TfNSW Reference: SYD17/00705/03

DPI&E Reference: SSI 8441

## **WARRAGAMBA DAM RAISING – EXHIBITION OF EIS - CREST ROAD, WARRAGAMBA**

### Environmental Impact Statement – Appendix O: Traffic and Transport.

Figure 24-32. Operational status of major river crossings and roads: 1 in 500 chance in a year flood event

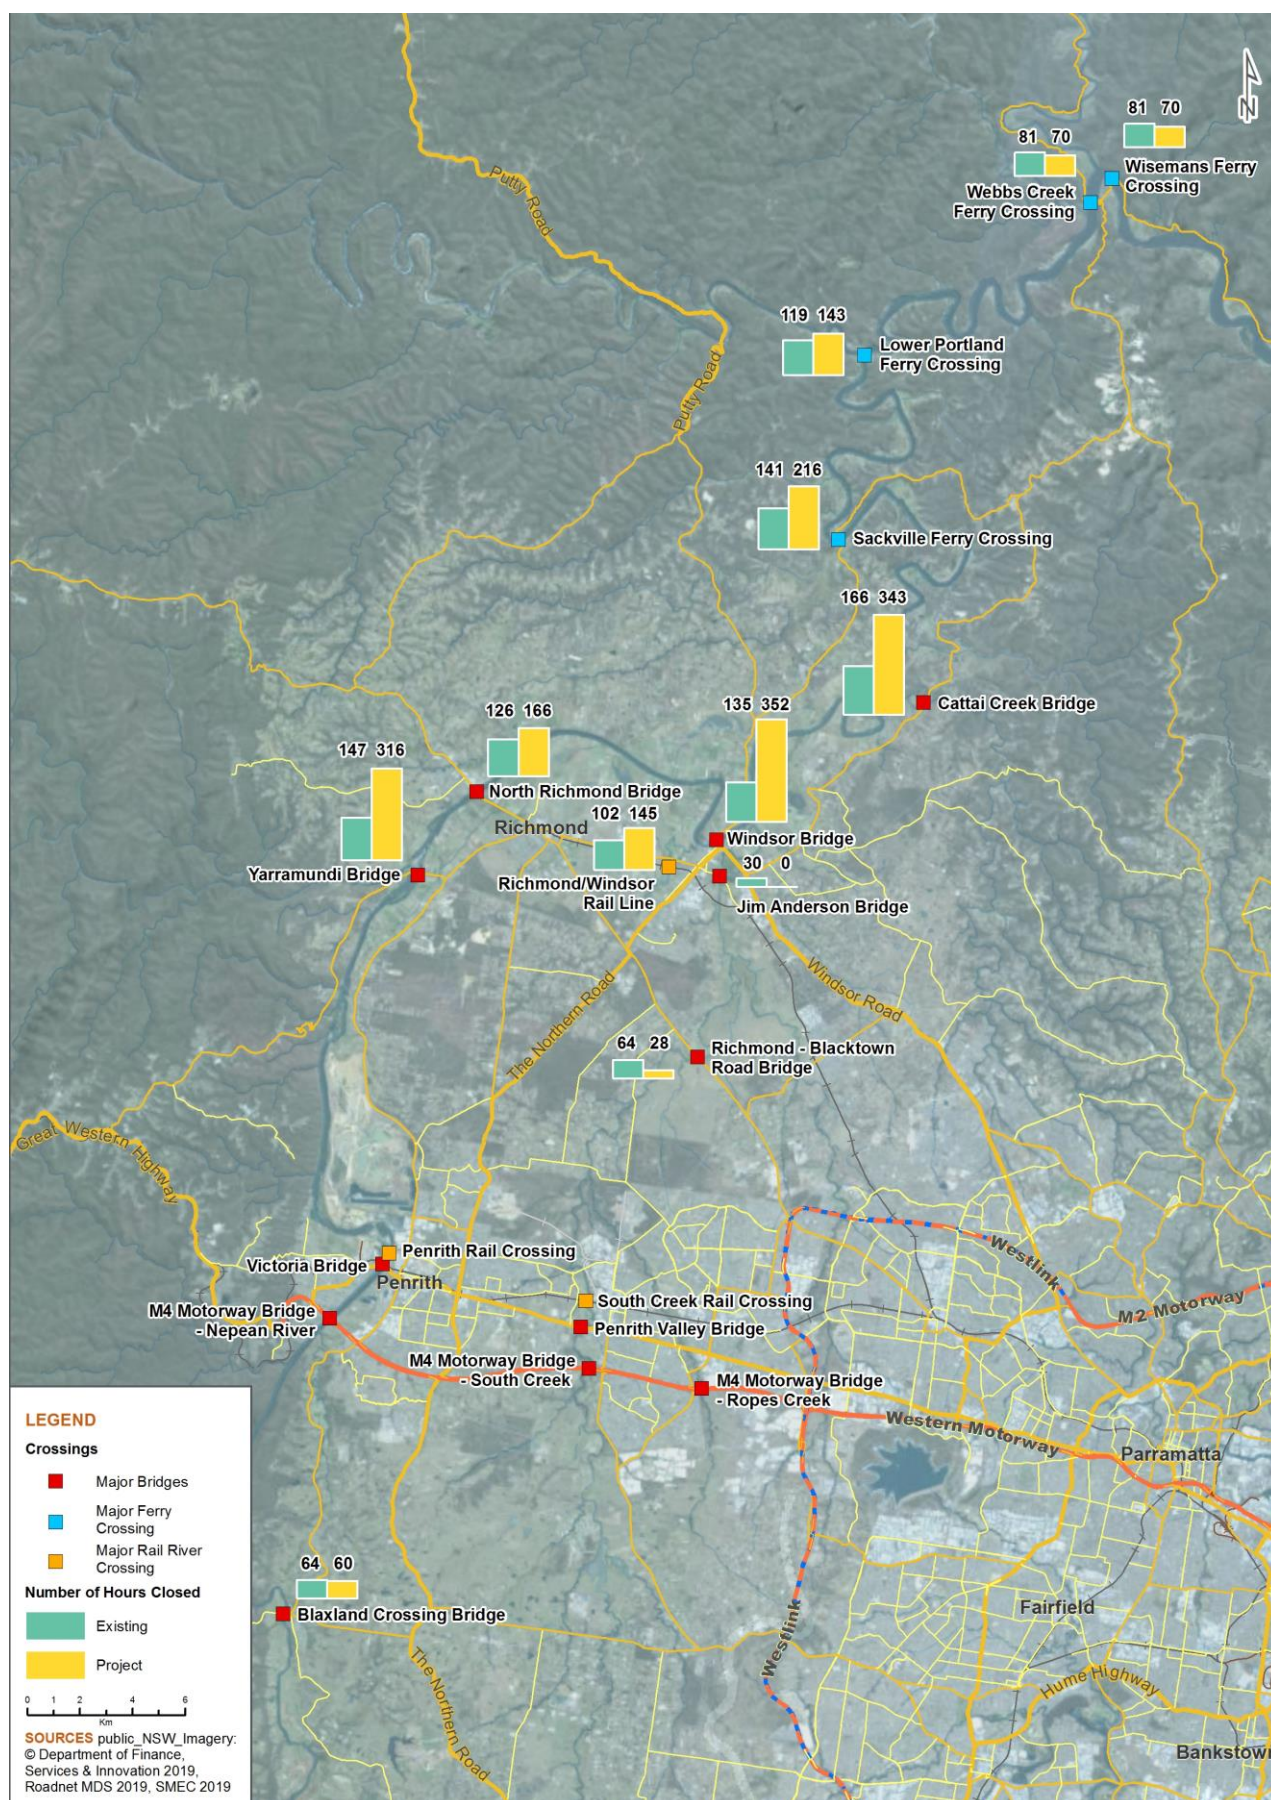
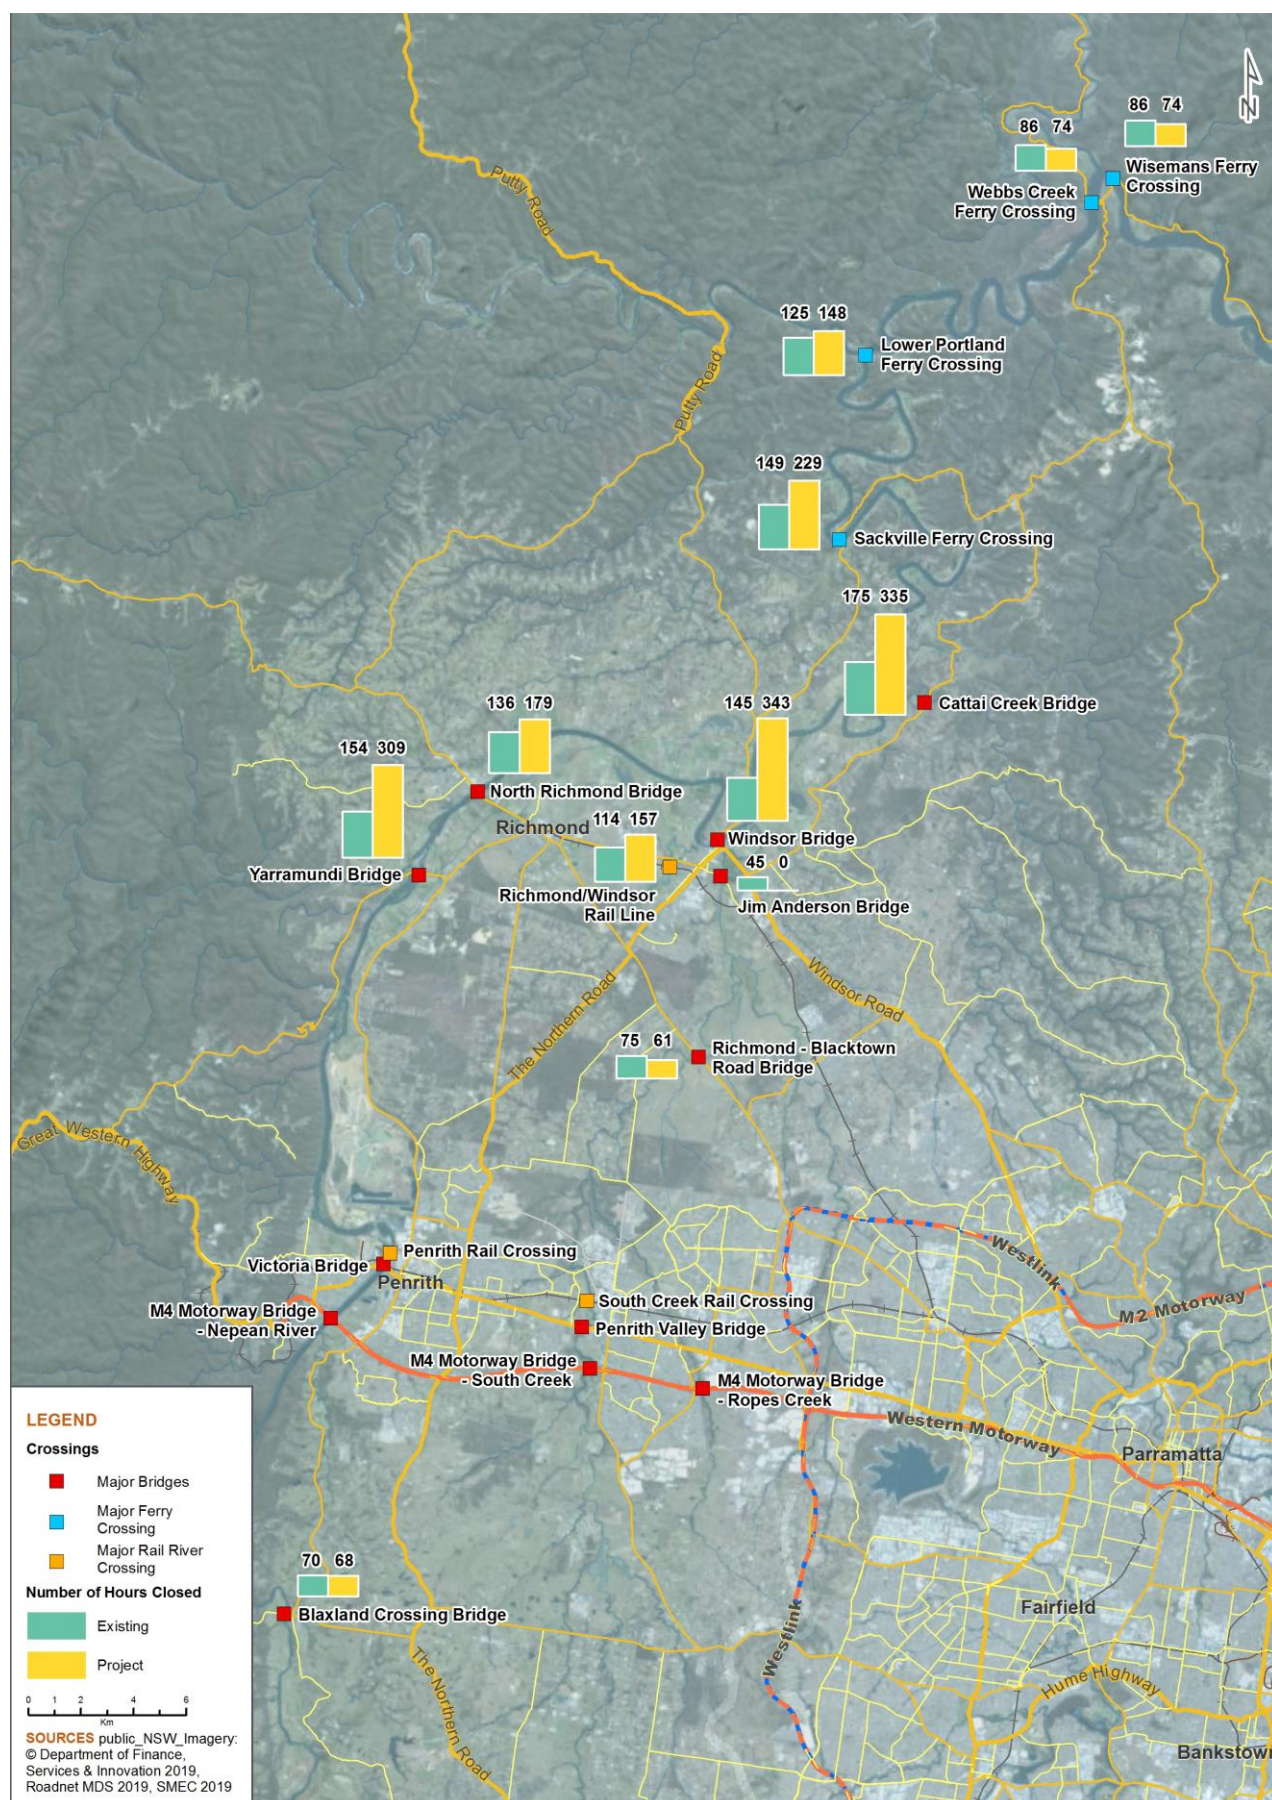
Section 5.2.2 discusses the project’s impact on major road river closure times due to flooding. The report indicates that four bridges are severely impacted by this project as shown in the excerpt below:

- i. Windsor Bridge (Bridge Street) forms part of the Wilberforce Road (state road 182) with an estimated traffic volume of 19,300 AADT in both directions.
- ii. Cattai Creek Bridge and Yarramundi Bridge are similarly part of state roads 181 and 570 respectively. Traffic volumes travelling along Springwood Road are estimated at 5,000 AADT.

It is noted that the only mitigation proposed as detour arrangements to mitigate these delays.

TfNSW would like to understand if there have been any other mitigation measure explored other than detour arrangements.
